# **M3 Junction 9 Improvement**

**Scheme Number: TR010055**

## **5.1 Consultation Report Appendix E - EIA Scoping**

# **SCOPING OPINION:**

**PROJECT STAGE**  
 PCF STAGE 3

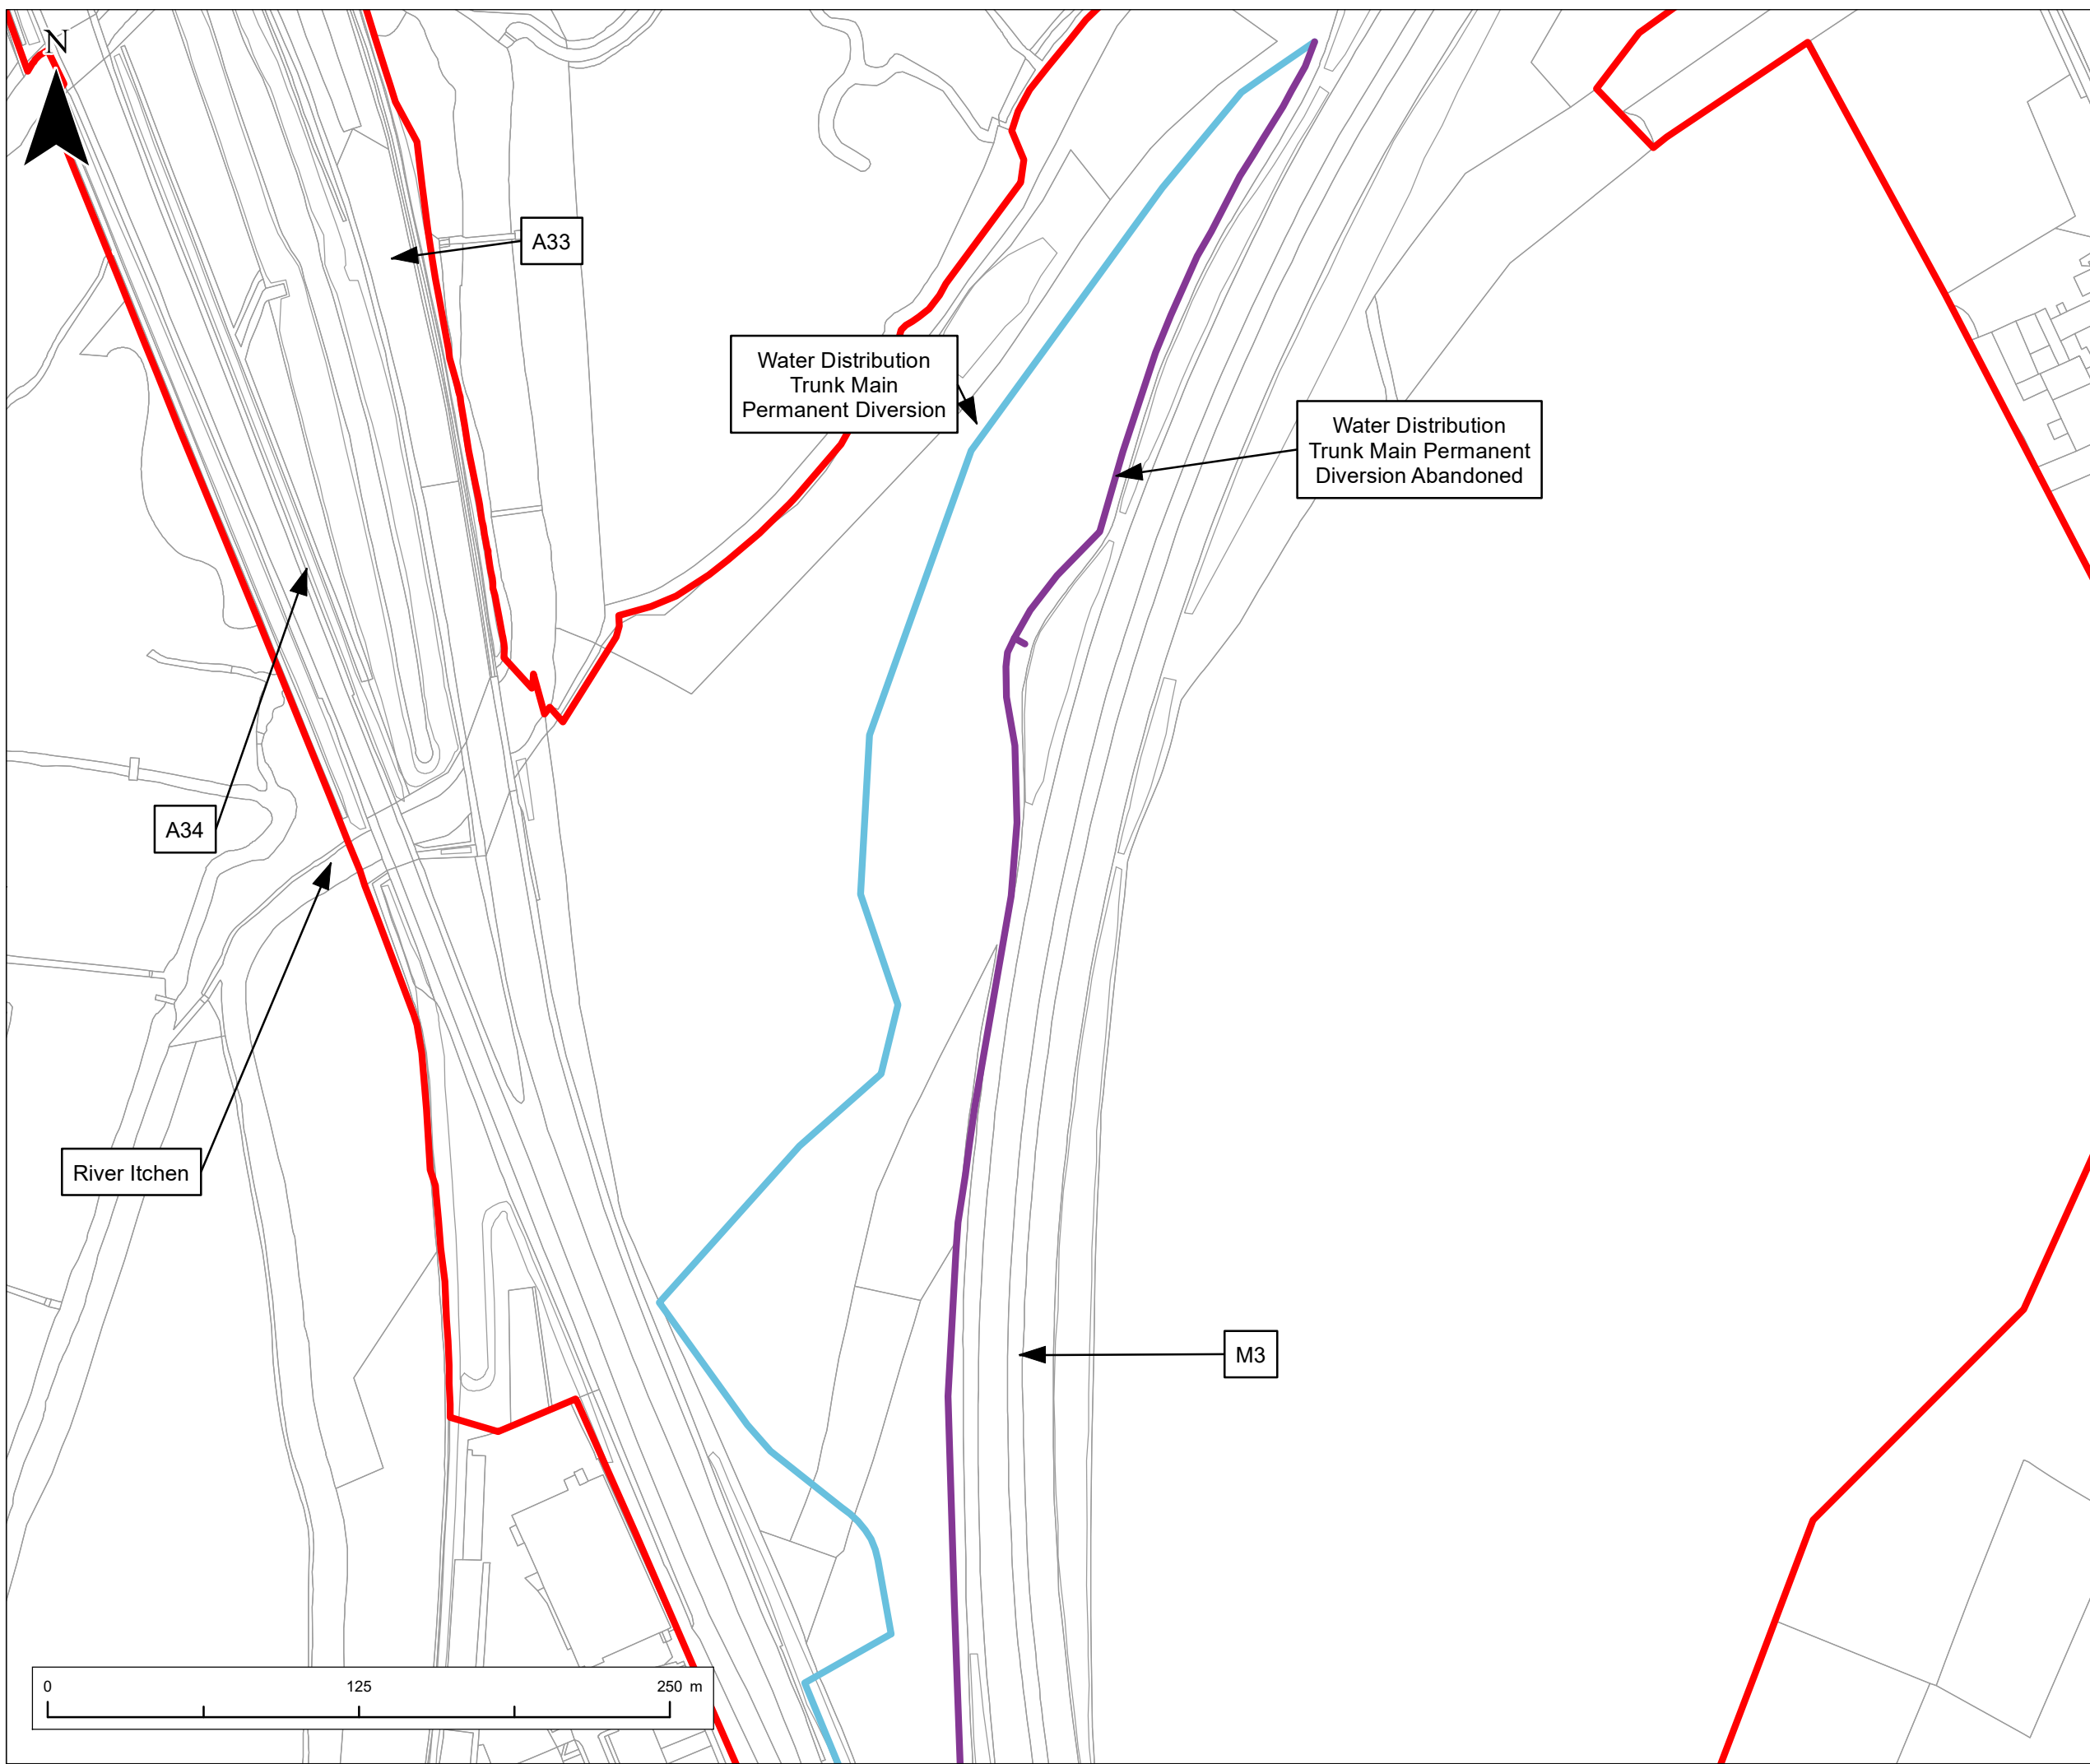
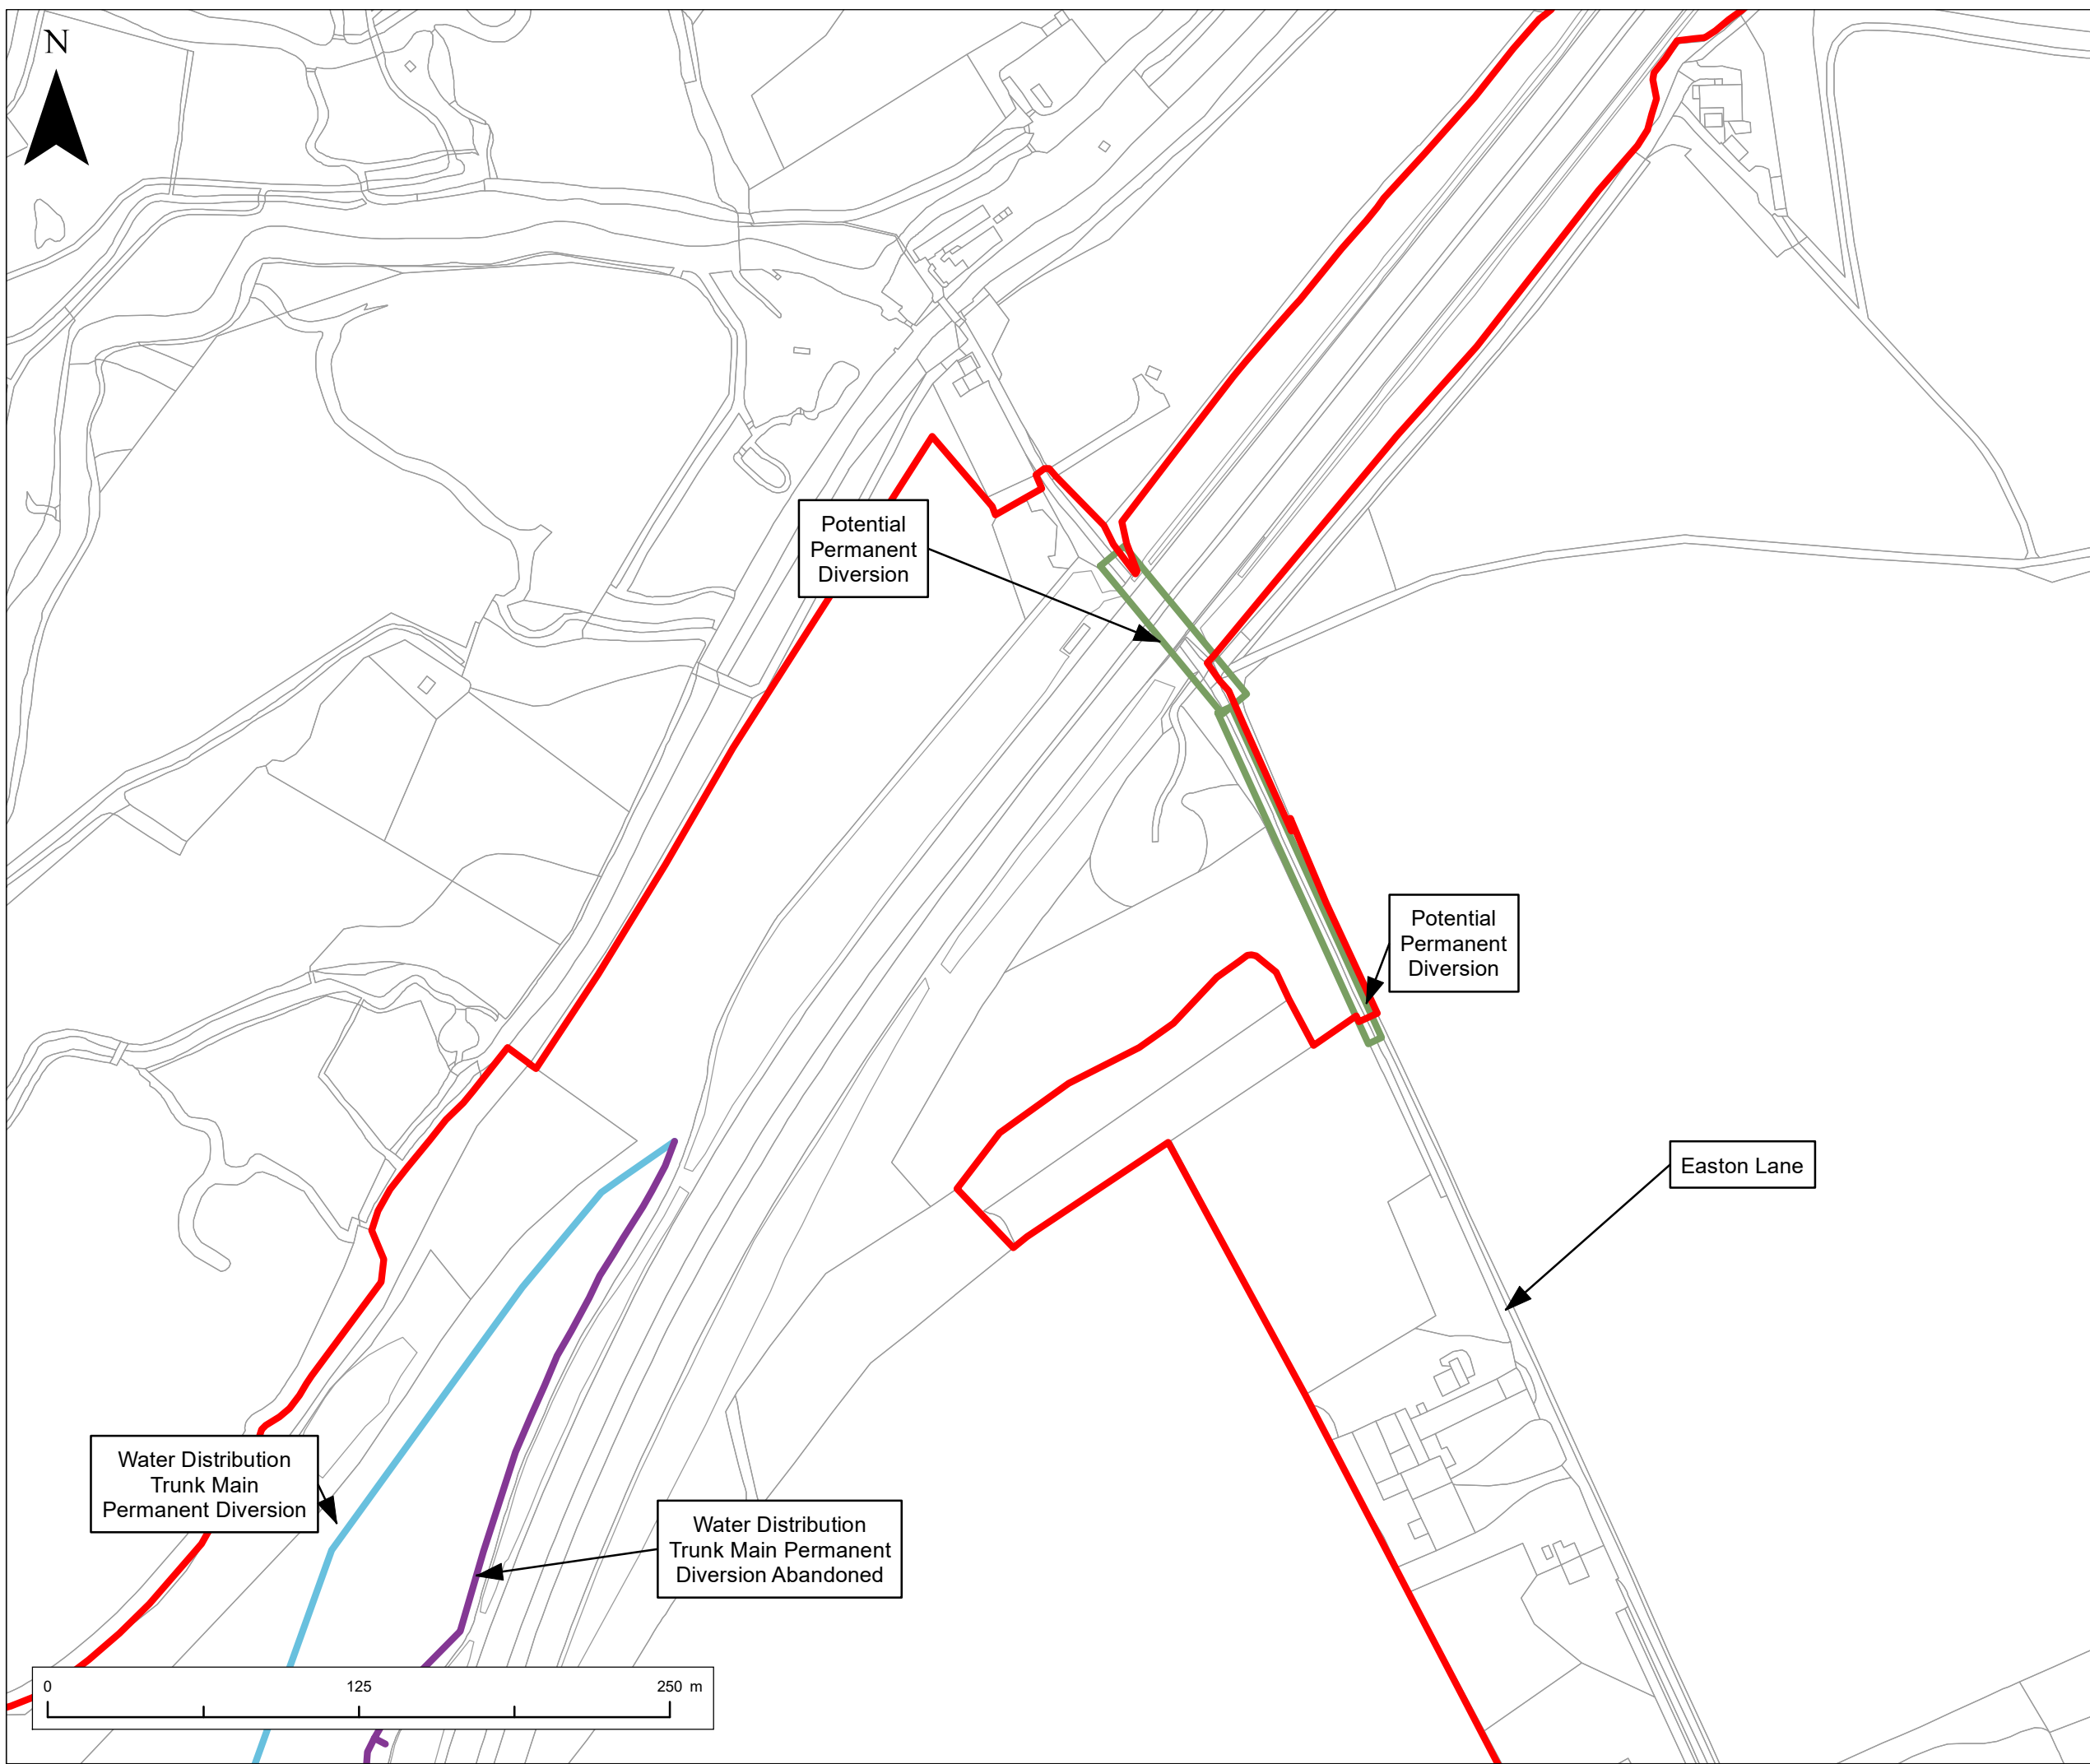
- 2.3.4 It is considered that the Proposed Development may require the diversion of various cables and utilities. This will necessitate associated ground moving activities, such as excavation and the establishment of temporary work areas. However, limited further information is provided on any diversions. The Applicant should ensure that the ES provides specific detailed information on this element of the Proposed Development, including plans to identify the diversions, and should ensure that any assessment is consistent with works specified within the dDCO.
